BOGNOR REGIS GOLF COURSE – PROPOSED NEW GOLF COURSE ACCESS – A259 GREVATTS LANE

Stage 1 Road Safety Audit – Designers Response

JNY10830-06
RSA 1 Designers
Response
Version 02
29 July 2022

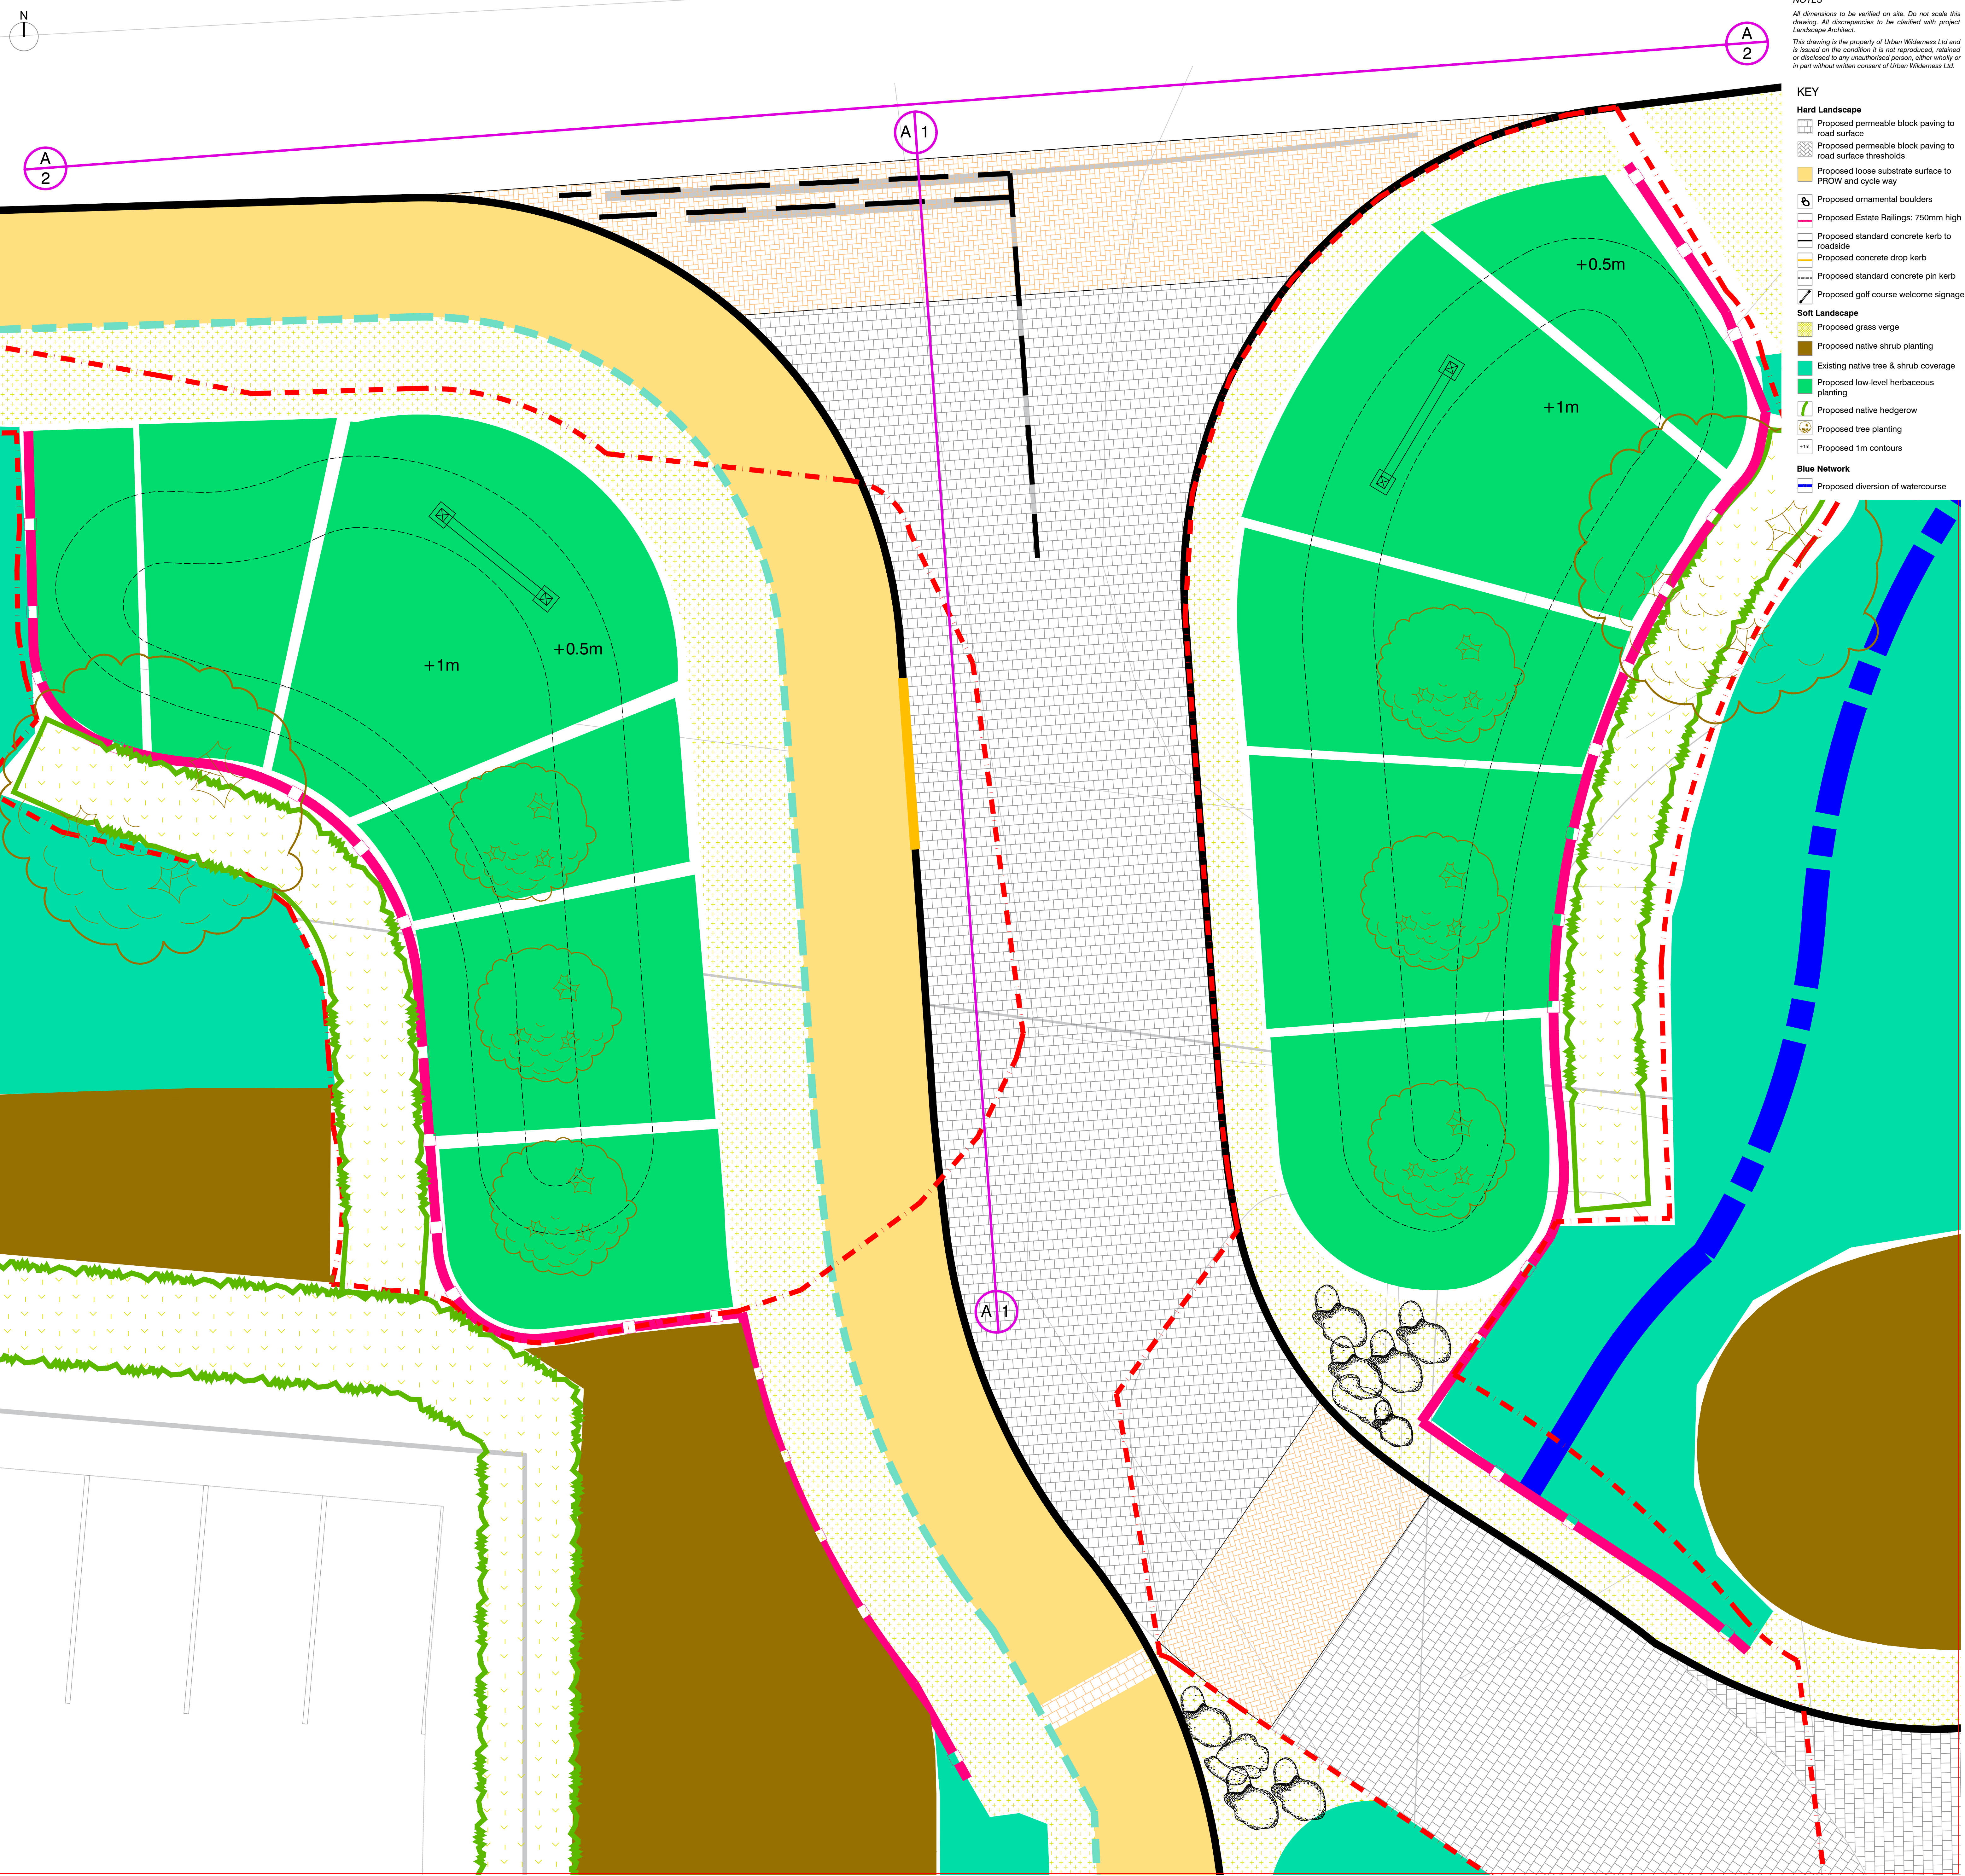
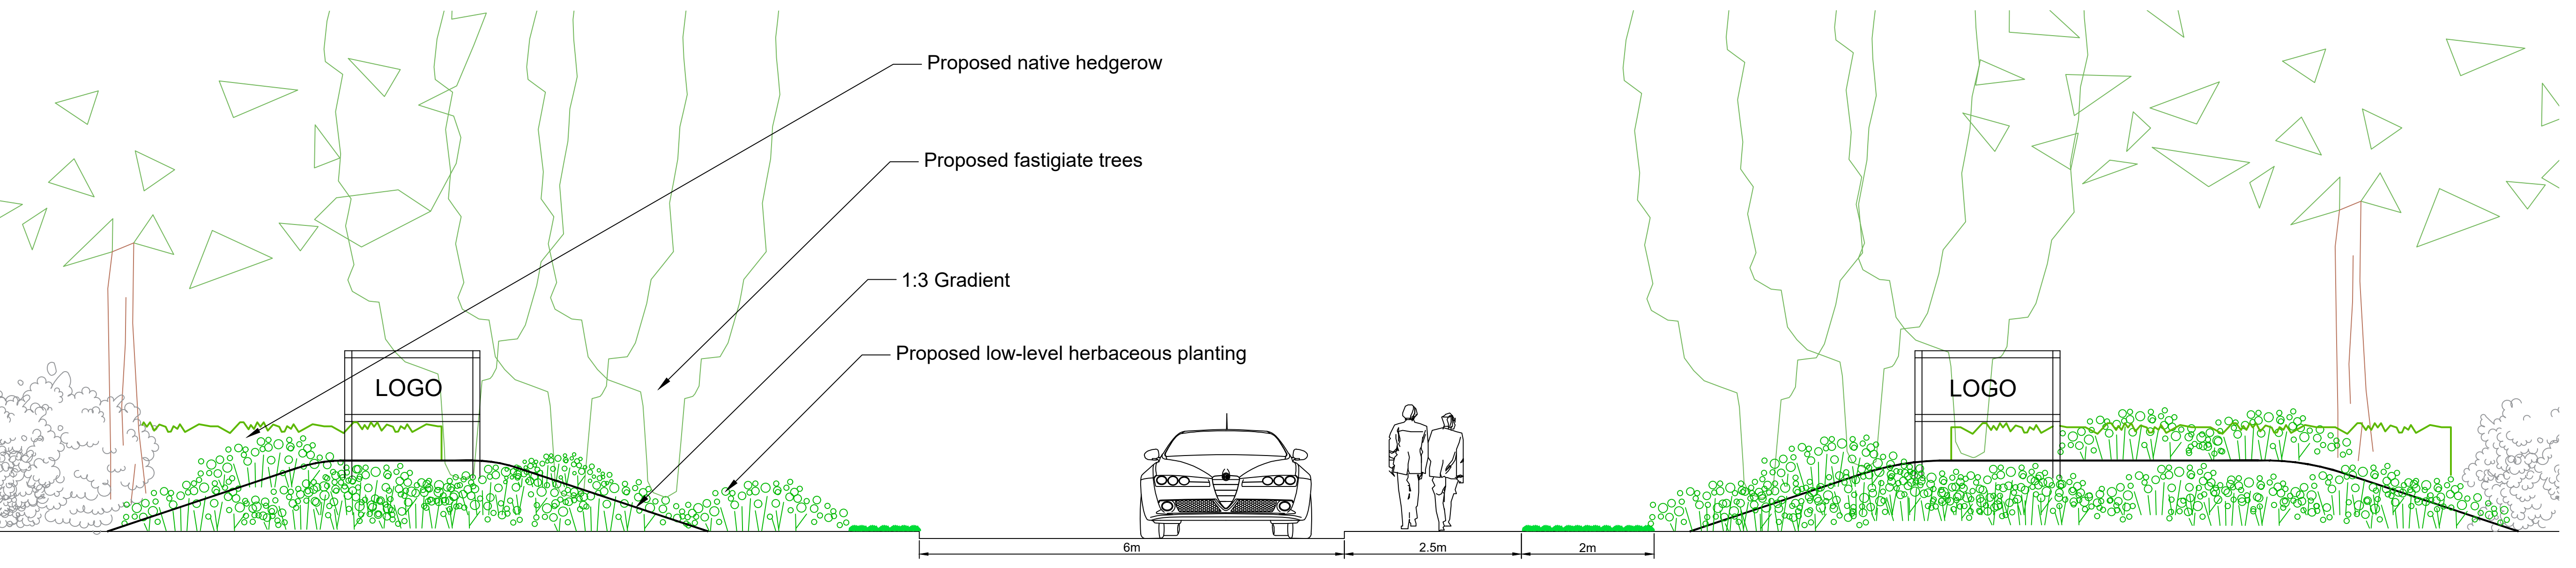
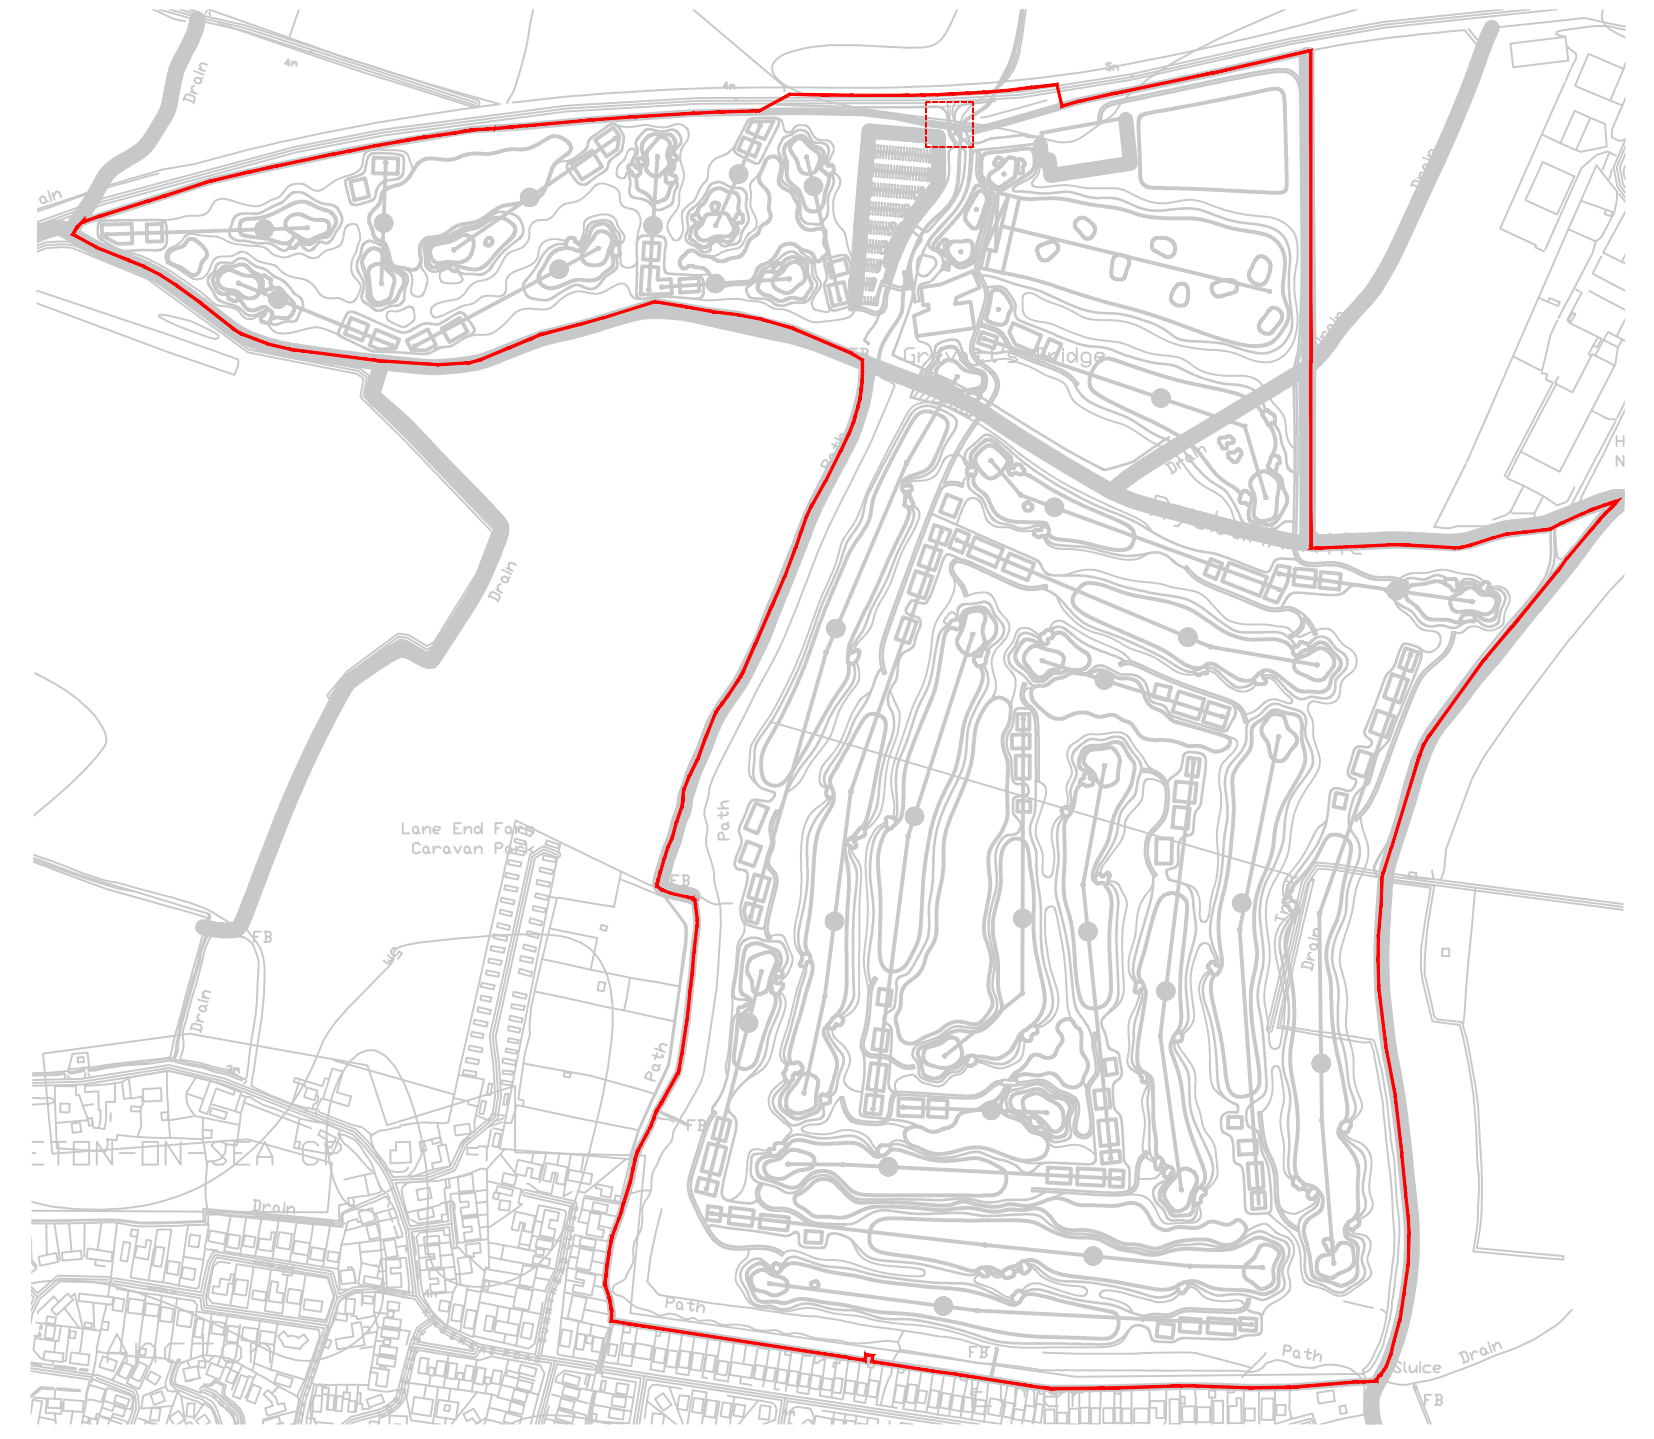
3.4-3	Summary: Width of refuge island may not accommodate cyclists crossing the carriageway. Risk of vehicle to cyclist type collisions. The drawing indicated that a refuge crossing facility is proposed to the west of the proposed development access junction. Proposed widths are not indicated. The existing facility along the northern side of Gravatt's Lane is a shared facility. This island, if implemented, would act as a refuge for pedestrians and cyclists to cross the carriageway in two stages. A lack of sufficient refuge width may increase the risk of cyclists overhanging the approach traffic lanes. This may increase the risk of vehicle to cyclist type collisions. Recommendation: The Audit Team recommend that the proposed refuge island can safely accommodate both pedestrians and cyclists waiting to	The proposed traffic island has been increased to provide a depth of 3m, the width is 3m which is considered sufficient for the likely level of use and provides a suitable safe waiting area for cyclists and pedestrians.	Accept Auditor recommendation and Design Organisation's response to it.	That depending on the outcome of the Departure from Standard as mentioned alongside point 1 above, the refuge be provided as per the Design Organisation's proposal and in accordance with other WSCC requirements for kerb-to-kerb widths either-side of it at 4.0m (for both east and west running lanes).

5	Summary: Lack of pedestrian/cyclists' provision may result in pedestrian/cyclist to vehicle collisions. The drawing indicates that a refuge island is proposed on Grevatts Lane to the west of the development access junction. Dropped kerbs and tactile paving are not shown on either the	Recommendation accepted. Dropped Kerbs and tactile paving have been added to the access layout.	Accept Auditor recommendation and Design Organisation's response to it.	That dropped Kerbs and tactile paving be provided to the access layout in the locations highlighted in the Auditor's recommendation.

AUDIT REF	Problem Summary and Recommendation	Designers Response	WSCC Comments	Agreed RSA Action
	northern or southern side of Grevatts Lane. This may increase the risk of pedestrian/cyclist trip hazards and /or vehicle to pedestrian /cyclist type collisions. Recommendation: The Audit Team recommends that appropriate dropped kerbs and tactile paving are provided.			
6	Summary: Lack of signage and corduroy paving on the shared use facility may increase the risk of cyclists to pedestrian type collisions. As part of the scheme proposals a new section of shared provision is proposed between the refuge island and the development site access junction linking to a footway only provision on the western side of the development access road. The drawings provided for this stage of audit do not indicate any corduroy paving to warn blind/ Partially sighted users of the potential presence of cyclists. This may increase the risk of cyclists to pedestrian type collisions. Recommendation: The Audit Team recommend that the appropriate form	Recommendation Accepted: Corduroy tactile paving has been added to the layout.	Accept Auditor recommendation and Design Organisation's response to it.	That corduroy and tactile paving be provided as part of the finished scheme layout as-per the Auditor's recommendation.
